Your Ref :
Our Ref : AW/139/18/NMA

Non-Material Amendment following a grant of planning permission AW/223/17/HH to remove the proposed french doors, retain existing window and enlarge the proposed bi-fold doors on the rear (east) elevation.

5 Larchfield Close, Aldwick, ,

Rear Elevation Proposed (East)
Scale 1:100

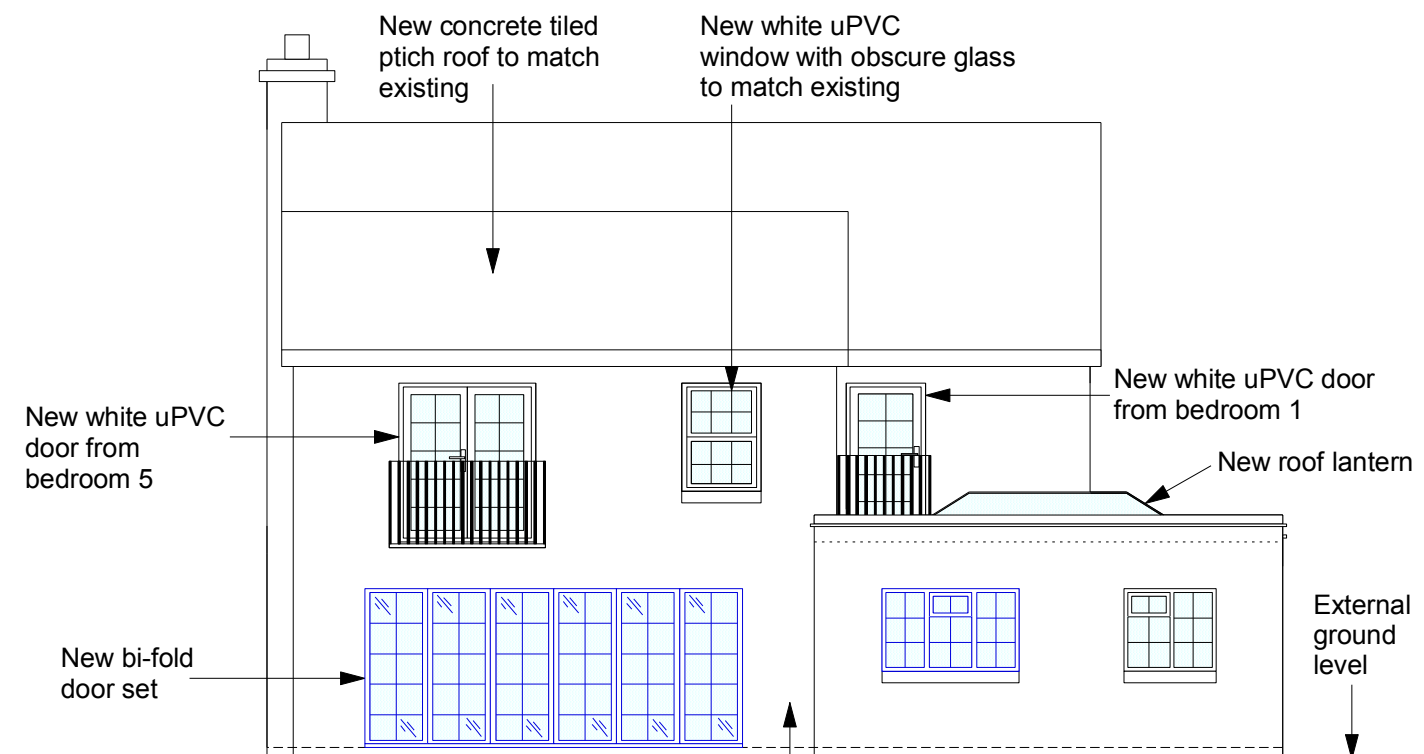
- 1) Removal of a secondary set of French doors on the rear elevation and retention of the existing window.
- 2) Enlargement of the proposed bifold doors from 3.2 metres in length to 5 metres in length on the rear elevation.

Therefore, drawing nos. AB003 Rev C dated April 2018 and AB004 rev C dated April 2018 become the approved plans for AW/223/17/HH.
